Memorandum
Department of Planning and Urban Development
Planning Division

DATE: June 23, 2011

RE: **Second Tee Business Park – Level II Site Plan Amendment**

Drawing file: PEZ.2015-118.Plan Amendment - Staff Level II / 4th amend plat Sec.Tee Bus Pk 11.29.2015.pdf

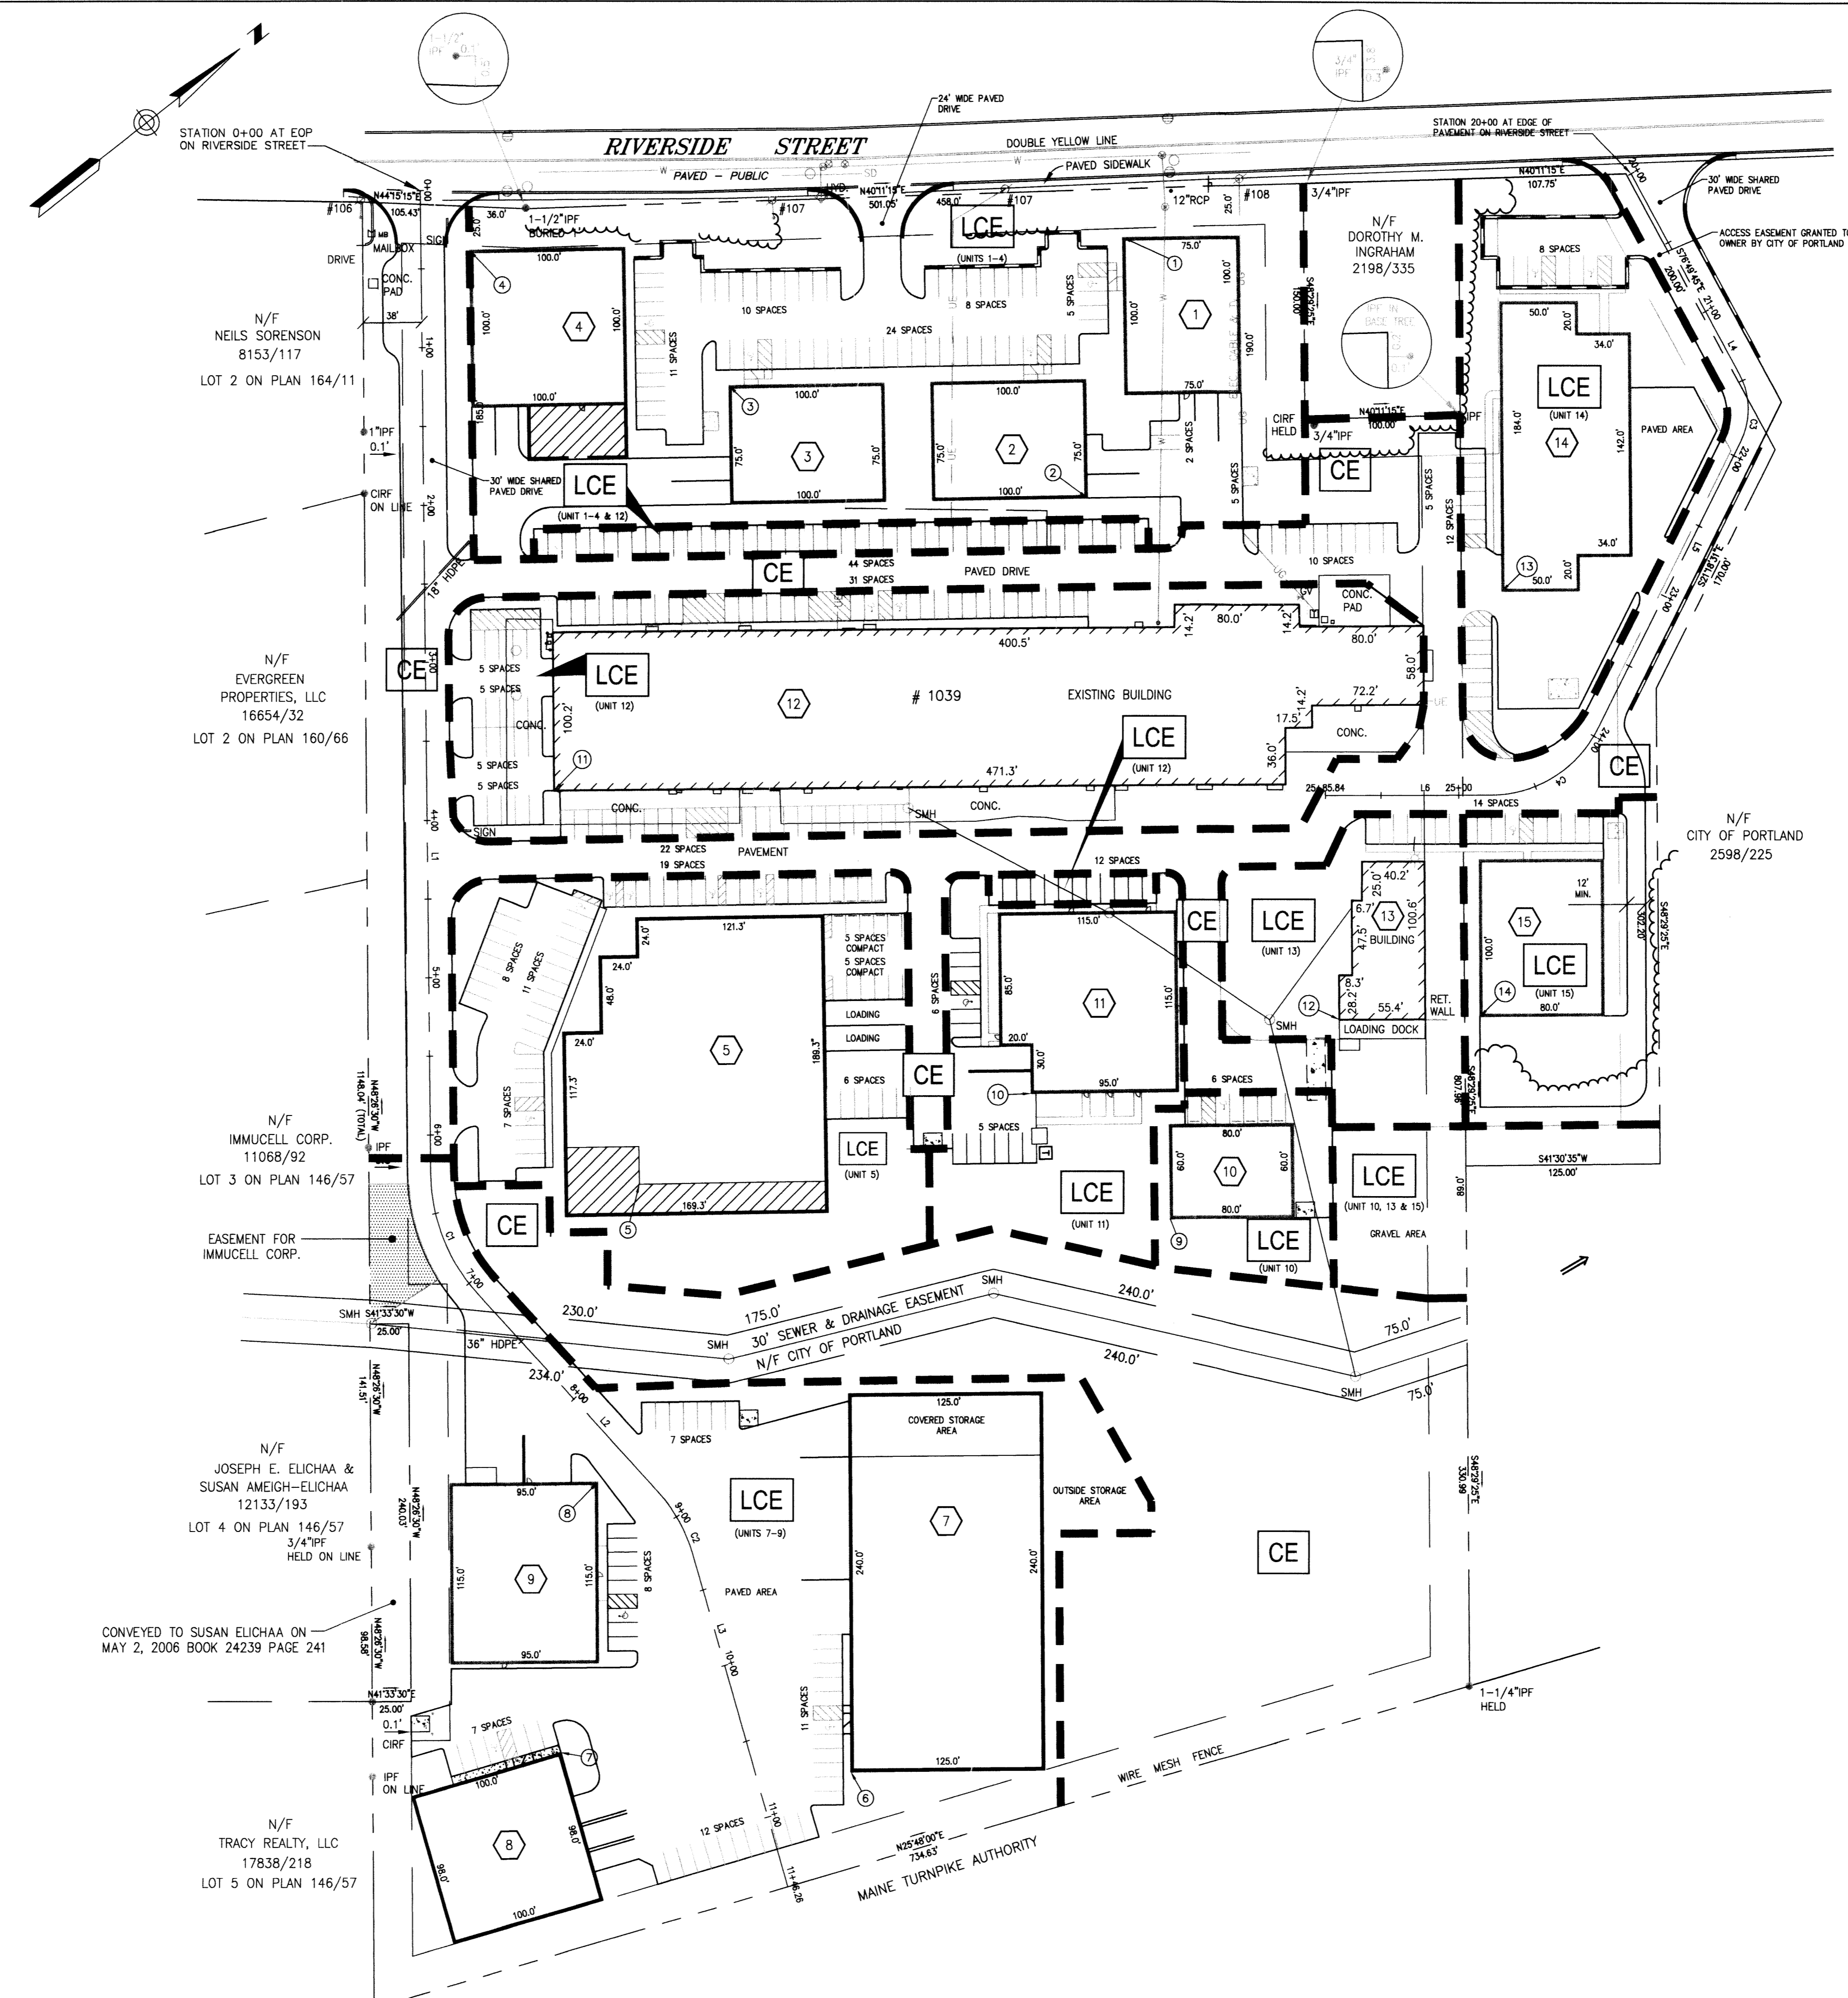
1. The plan set does not include a copy of the approved subdivision plan and any amendments to that approved plat that are being considered. As stated in the cover letter, "the applicant will be submitting a Fourth Amended Condominium Plat and Plan and Amended Declaration Agreement for Planning Authority and Corporation Counsel review and approval." Generally, amendments to subdivision plans are reviewed by the Planning Board; however there are exceptions. I cannot determine whether this application can be reviewed administratively or requires Planning Board review until the material for the fourth amendment is submitted for consideration.
